**Subject:** RE: AL/106/19/DOC

Fiona has agreed the amended CMP Rev C. I have sent it to be signed off.

Claire Potts requires an email from you with a timetable on when the Energy Saving measures described in your energy statement, will be provided, before Condition 16 can be signed off.

**Subject:** AL/106/19/DOC

REV. No.	DATE	DESCRIPTION	INITIALS
Client			
Project	Westergate & Eastergate		
Title	External Works Layout Sheet 1	Scale 1:250@A0 Checked AMc	Date Mar '18 Drawn KT
Drawing No.	5655:40	Rev	H

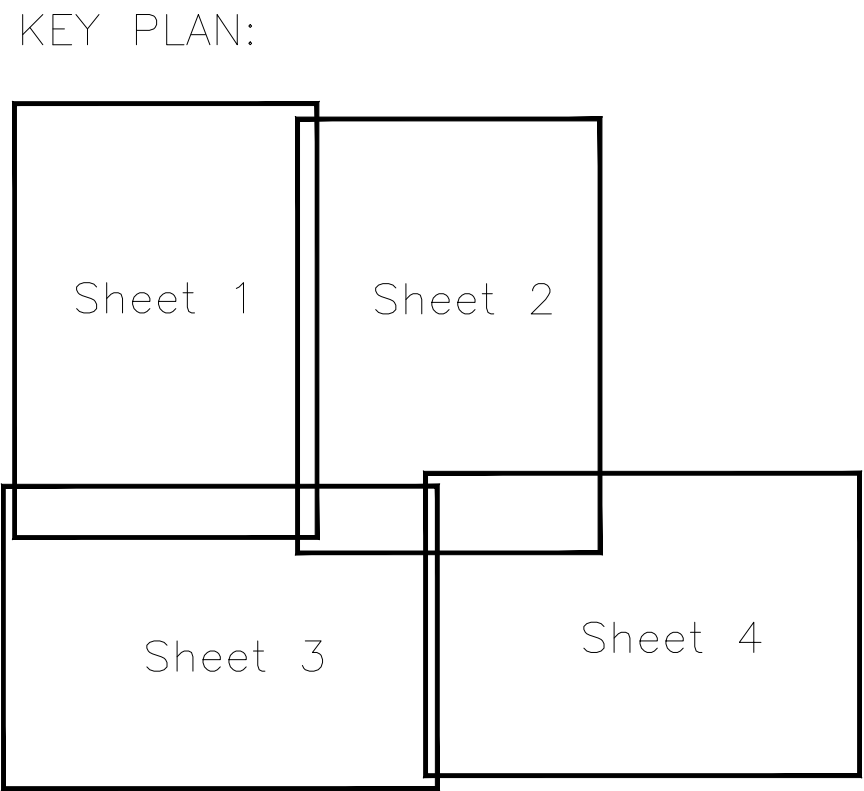
I haven't been able to find confirmation of the fact that the Lighting Schedule complies with Zone E2 of the ILP guidance – as discussed there are a couple of documents that the Planning Portal seems intent to keep me away from! If you could point me to the documentation that contains the Zone E2 confirmation I would be very grateful.

DRG. No.:		20627/001/CMP	REV.: C

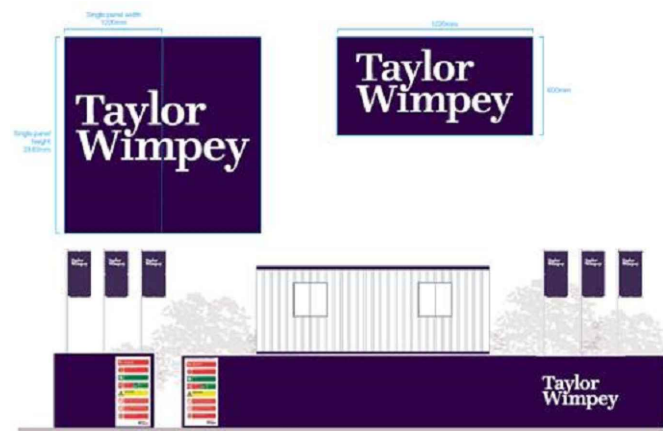
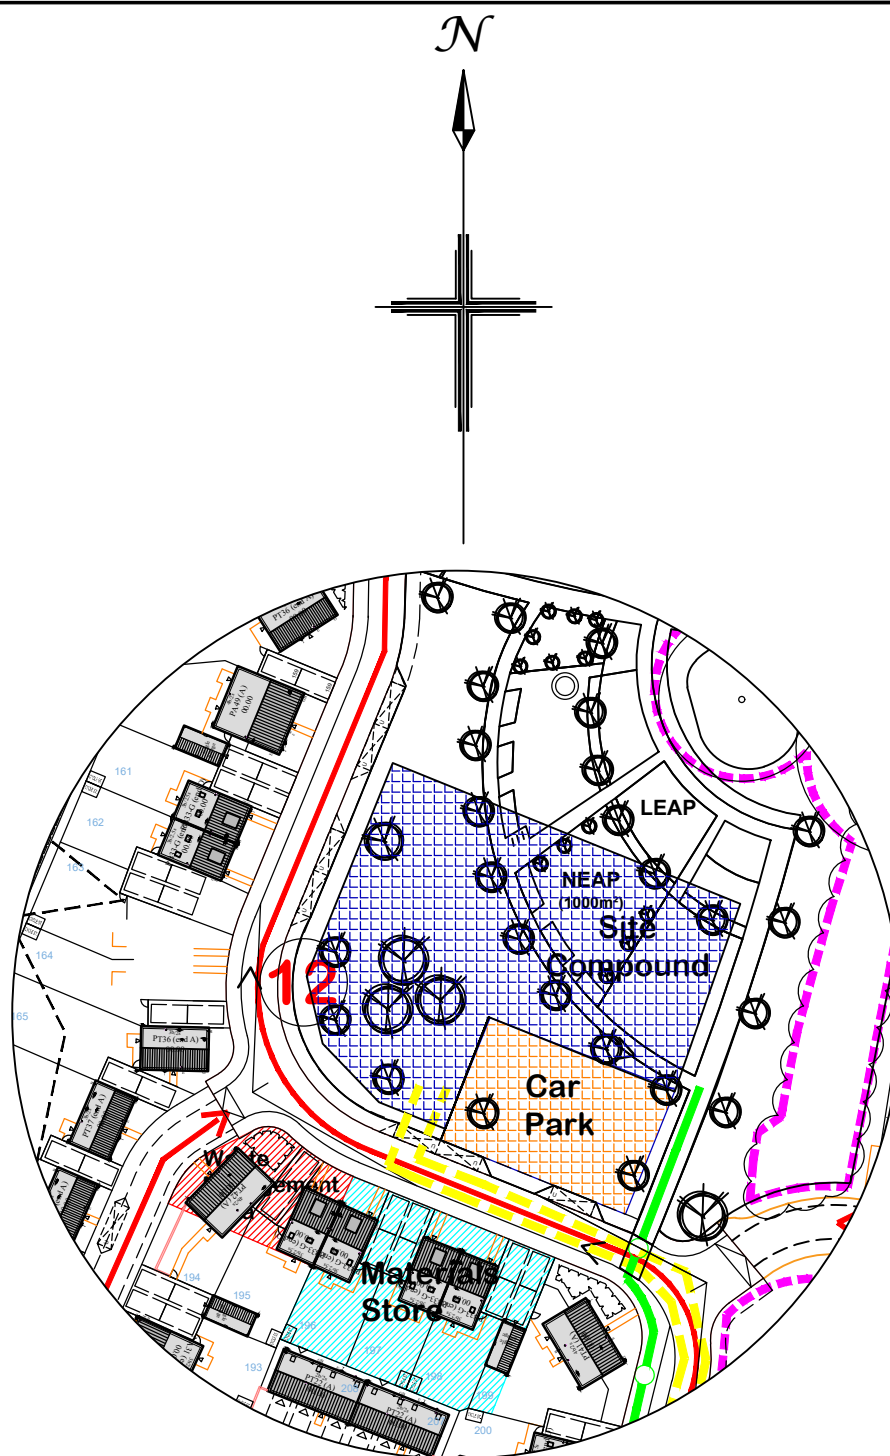
Further to my previous response to this application for Condition 7 (CMP), I asked for further detail on their complaint procedure in the CMP should there be a lighting complaint. They have just stated 'in the event of any queries or concerns the site manager is contactable'. Given that we have already had a lighting complaint about this

site, I would appreciate it if they could expand more to advise of their complaint procedure in the event of a lighting complaint. I am satisfied with the noise part of the CMP, now they have put more detail into it.

Here is an updated layout. I have added further details outlining the procedure in the event of a complaint relating to lighting.
